Our Ref: AW/264/19/HH

Town & Country Planning Act 1990 (as amended)
Town & Country Planning (Development Management Procedure) (England) Order 2015
Application for Householder Planning Permission

Development Removal of existing conservatory and erection of single storey side extension.
Location 7 Kenlegh Aldwick Felds

sheet 3 a of 3

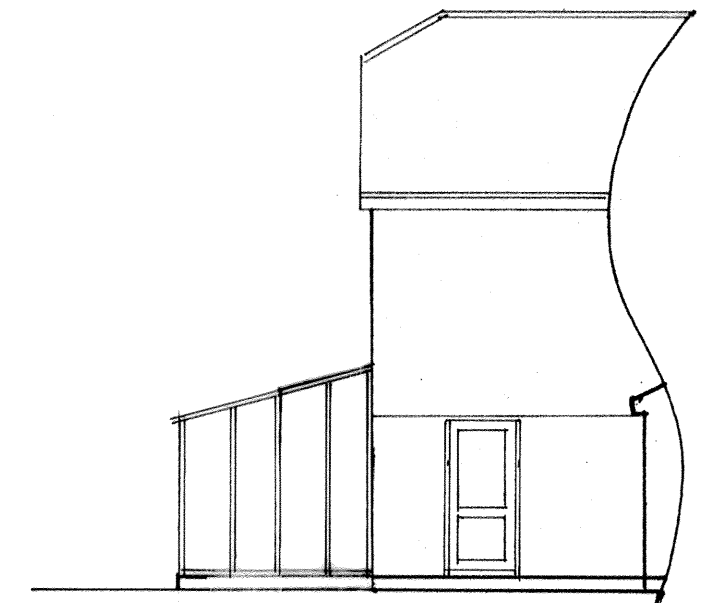
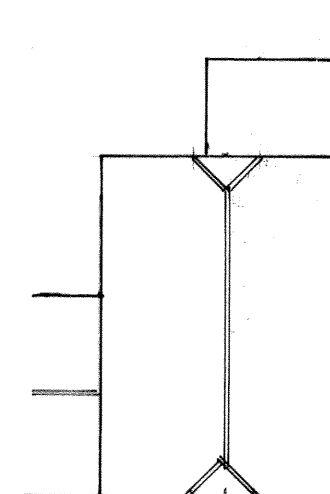
The east and west existing elevations have been labelled incorrectly. Please amend and re submit.
